## **M25 junction 28 improvement scheme**

**TR010029**

### **9.75 Applicant's response to Hinson Parry & Company on behalf of Mr and Mrs Jones of Grove Farm's Deadline 4 submission**

## REP4-036 HINSON PARRY & COMPANY ON BEHALF OF MR & MRS JONES OF GROVE FARM – TRANSPORTATION & HIGHWAY SUPPLEMENTARY REPRESENTATIONS

Client	MR L JONES & MRS K JONES			
	FOR APPROVAL			
Project	GROVE FARM ACCESS, JUNCTION 28 M25 NORTHBOUND SLIP LANE			
	SUGGESTED ALTERATIONS TO GROVE FARM HIGHWAY ACCESS			
Status	Drawn	PL	Scale	1:500
Sheet Size	A3	Date	JAN 2021	Rev
Drawing No.	REDW-3396-111			Rev

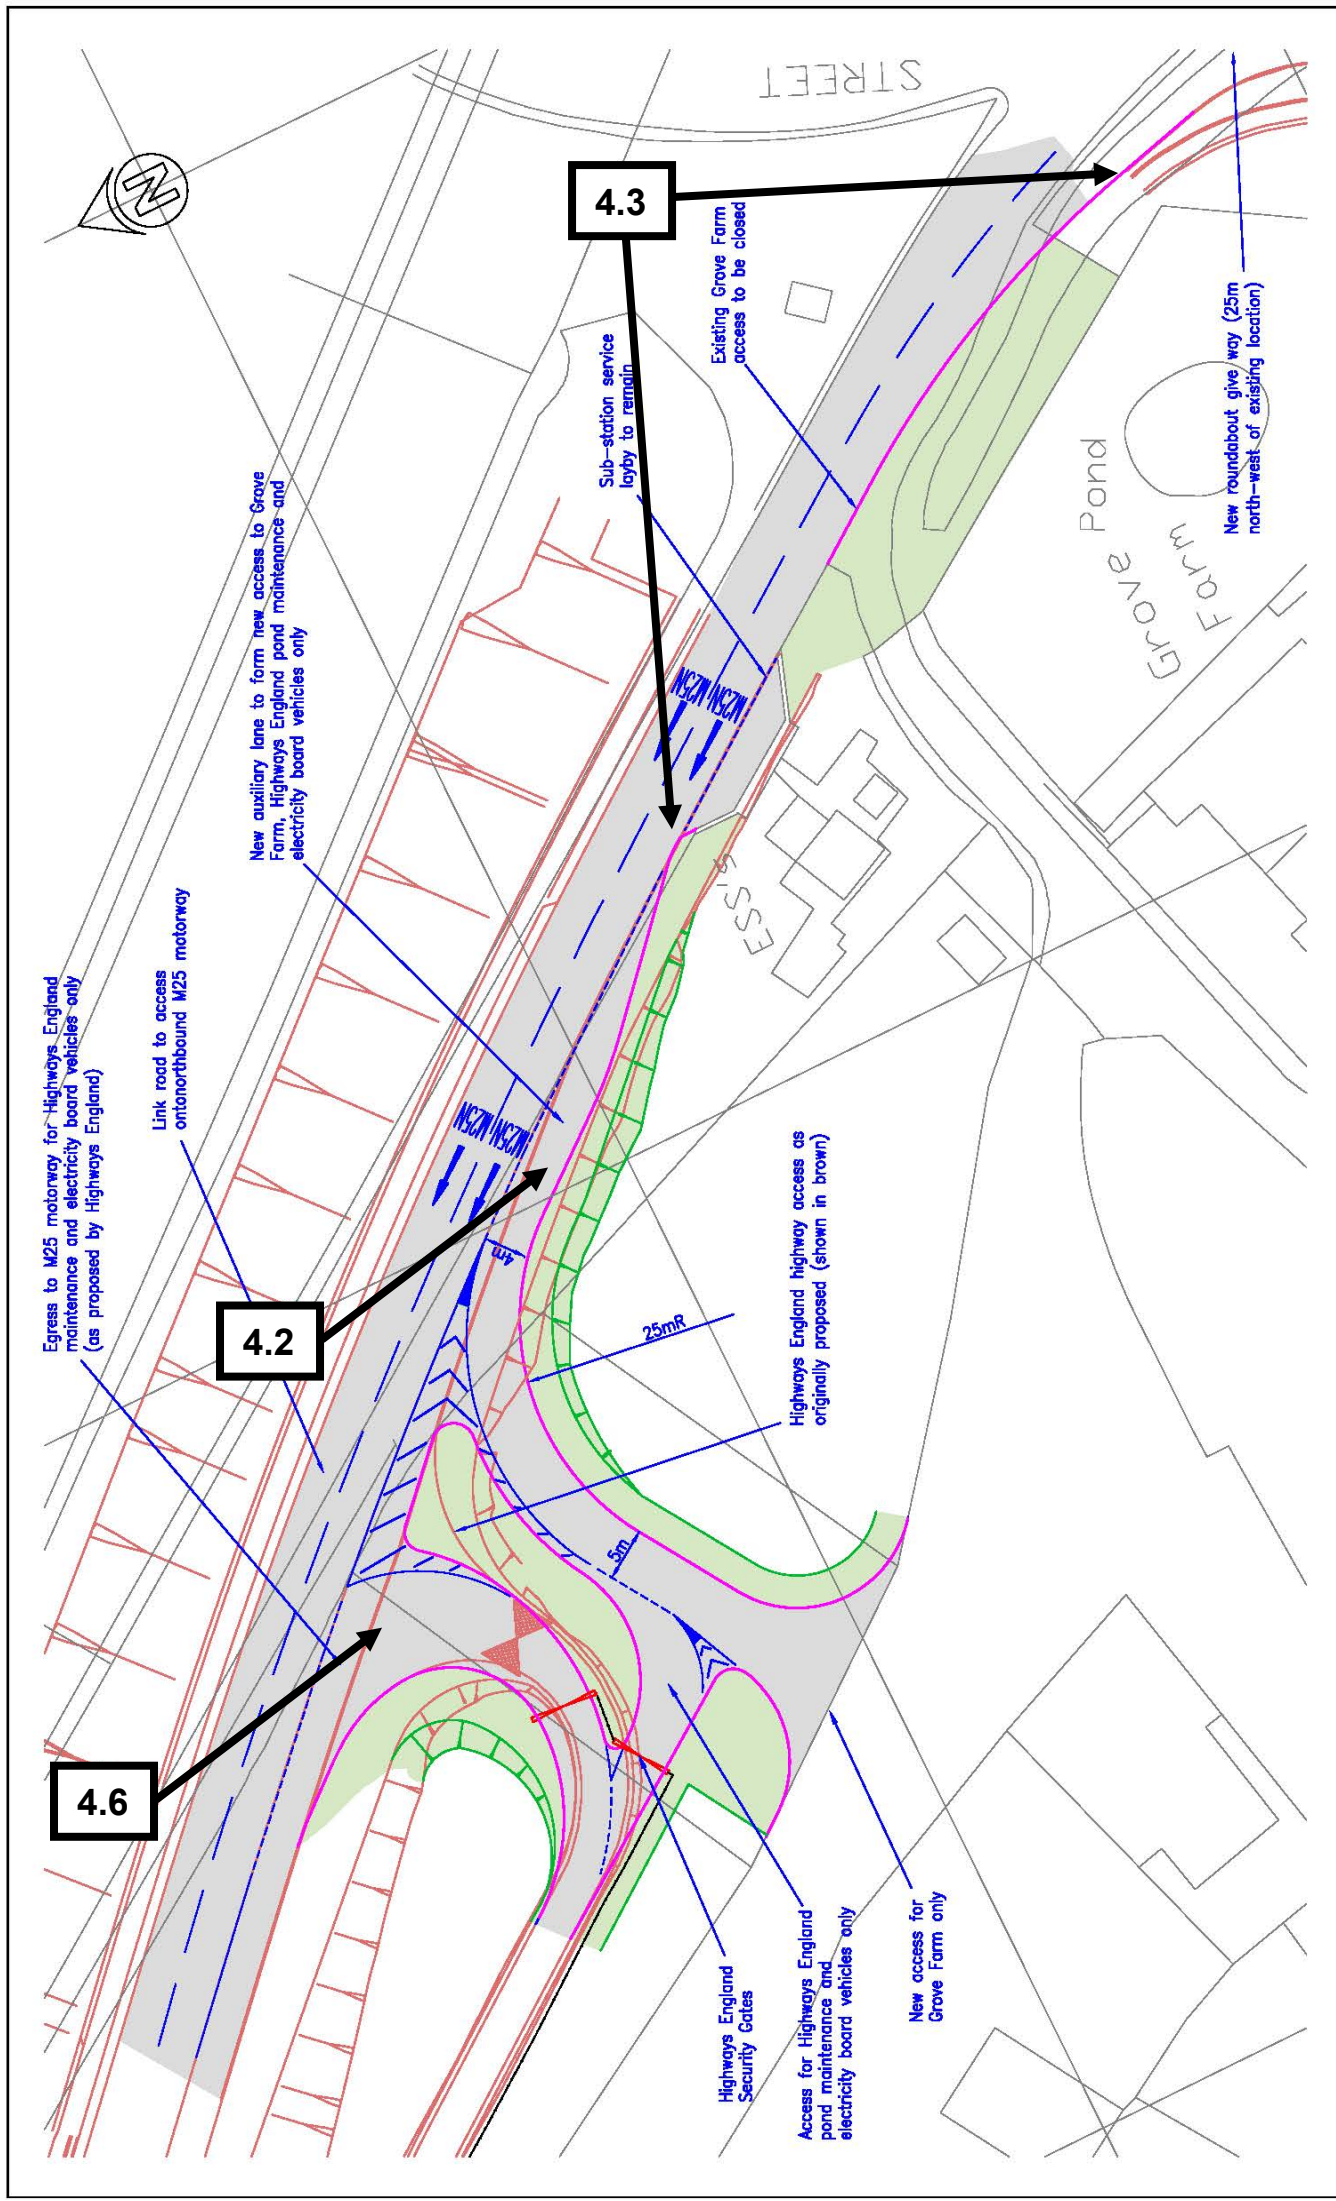
REP4-036-8	2.4 Given the new safety issues arising from retaining the Grove Farm access in its present location, we can see no practical reason why the relocation of the Grove Farm access could not be facilitated as shown on my <b>Drawing No. REDW-3396-115</b> . My proposals will not introduce any new conflicting vehicle crossing movements and will provide a safer access for the farm and no egress onto the M25 northbound on-slip for farm traffic.	Please see Highways England response to the Jones Family's written Representation (REP3A-022) with regard to access proposals from M25 northbound on-slip road. Highways England has reviewed the Jones Family's Deadline 4 submission (REP4-036) and maintains its position that it would not be appropriate to pursue these proposals.

Client	MR L JONES & MRS K JONES			Project	GROVE FARM ACCESS, JUNCTION 28 M25 NORTHBOUND SLIP LANE			
	FOR APPROVAL			Title	HGV ENTRY AT PROPOSED NEW ACCESS TO GROVE FARM			
Status	Drawn	PL	Scale	1:500	Sheet Size	A3	Date	JAN 2021
	FOR APPROVAL			Drawing No.	REDW-3396-113			
			Rev

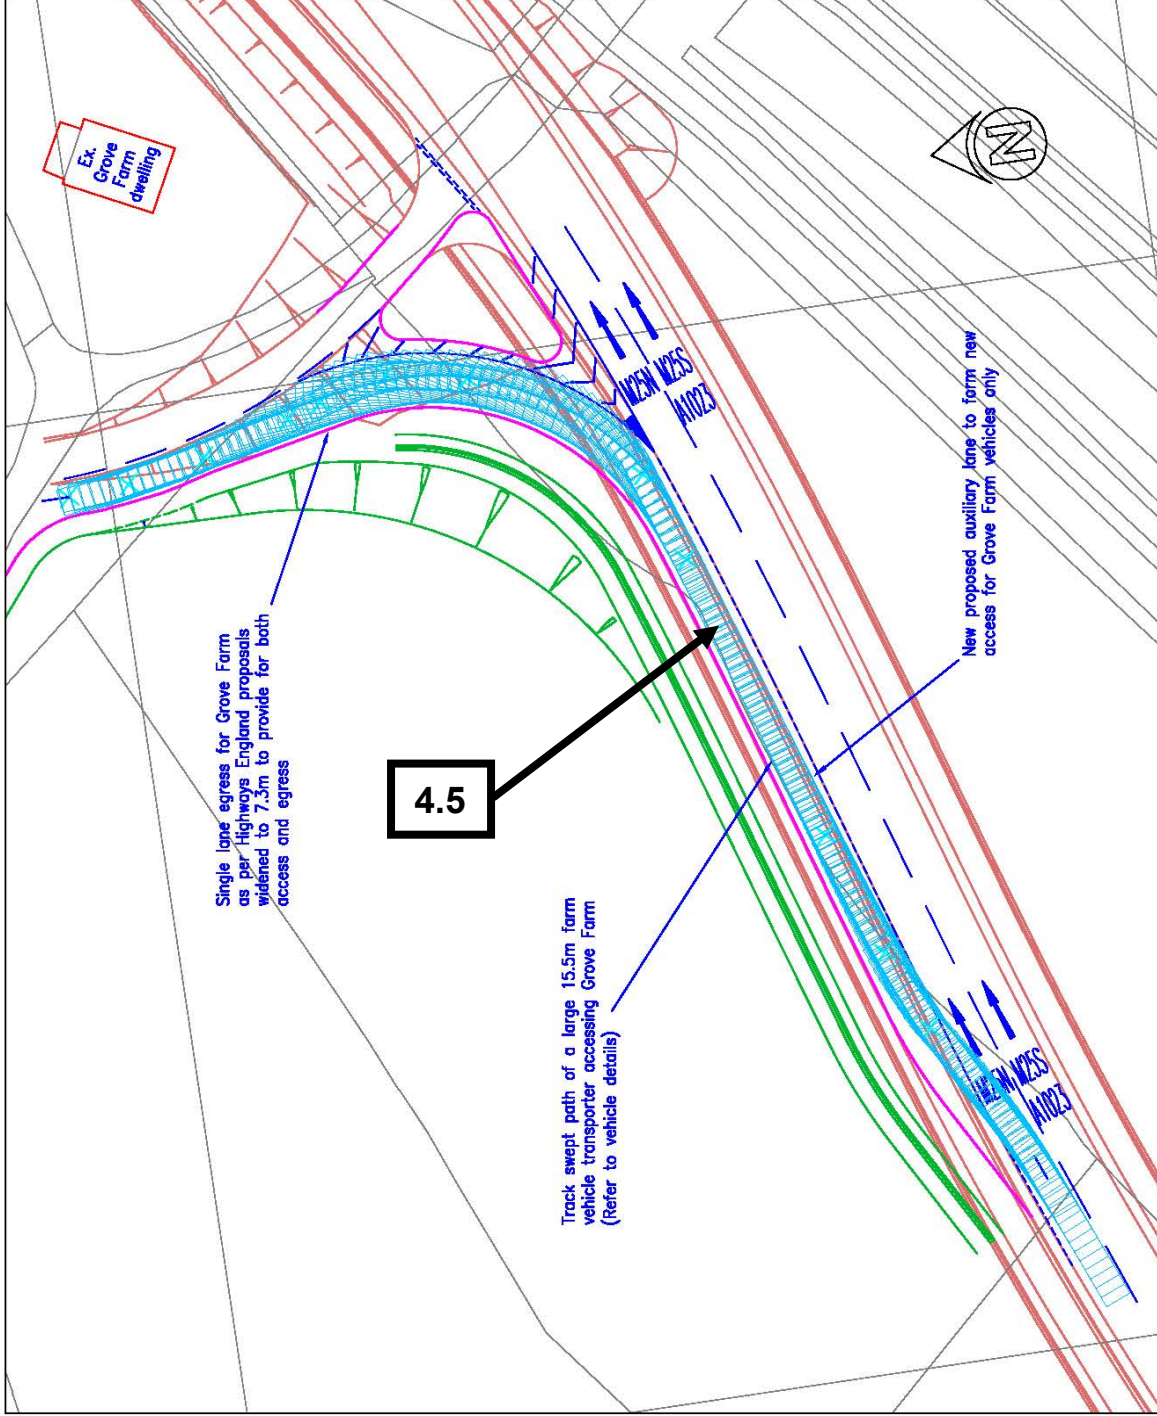
REP4-036-10	2.6 My <b>Drawing No. REDW-3396-113</b> which accompanied the first Written Representations (Ref: PMcL/3396d1/Feb 2021) showed a 15.5m long farm vehicle transporter leaving the M25 northbound on-slip and safely turning into the farm and a 12 metre rigid lorry leaving the M25 northbound on-slip and safely turning into the HE dedicated access road leading to the pond maintenance area in advance of the security gates. We consider a 12 metre rigid would be significantly larger than the longest vehicle expected to access the pond service area. The track included in the first Written Representations on <b>Drawing No. REDW-3396- 113</b> shows that this vehicle can turn into a dedicated waiting area in front of the HE security gates without obstructing traffic entering Grove Farm.	<p>Please see Highways England's response to the Jones Family's written Representation, in particular paragraph REP2-033-21 (REP3A-022). Highways England has reviewed the Jones Family's Deadline 4 submission (REP4-036) and maintains its position that it would not be appropriate to pursue these proposals as it is best practice to provide some buffer in situations like these as drivers may not stop their vehicle precisely in front of the gate. In a situation where a vehicle longer than 12 m was to enter this area, or if the vehicle was not stationed precisely in front of the gate, the access to Grove Farm would be obstructed with potential safety concerns.</p> <p>Whilst Grove Farm and the representatives have looked to increase the storage area as shown on Drawing No. REDW-3396-113, this does not change Highways England's position on the key issues of road safety on the M25 northbound on-slip.</p>

**Figure 3.2 – Grove Farm's suggested location for extra noise attenuation fencing**

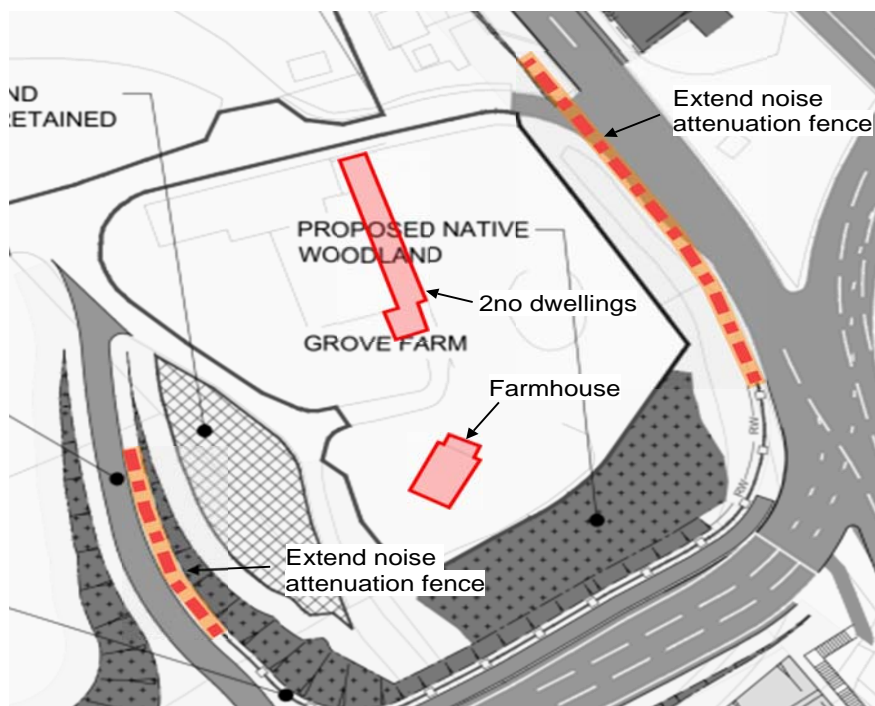
Response reference:	Representation Issue	Highways England Response
	<p>properties which would contribute towards mitigation of increased environmental traffic noise brought about by the HE Scheme. We request that HE include in an amended HE Scheme permanent noise mitigation measures surrounding Grove Farm as shown on my Drawing No. REDW-3396-115.</p>	<p>Agenda item 5.1 - The effects of the Proposed Development on the living conditions of the occupiers of Grove Farm (REP4-016).</p> <p>Highways England has continued to engage with the owners of Grove Farm and their land agent with regard to mitigation and some additional mitigation measures are being proposed.</p> <p>In addition to the planting proposed for the Scheme, in order to provide immediate year- round visual screening Highways England is proposing to install a visual screening fence adjacent to the proposed A12 eastbound off slip carriageway. A new commitment will be added to the REAC (Table 1.1, commitment LV0.6 and Table 1.3 LV1.11, TR010029/APP/7.3(3)) at a future deadline. These measures will provide adequate year-round mitigation for the relevant landscape and visual effects at Grove Farm. Highways England also intends to maximise the retention of established vegetation between the dwellings and the slip road, and landscape planting of a species mix in agreement with the owners of Grove Farm.</p>
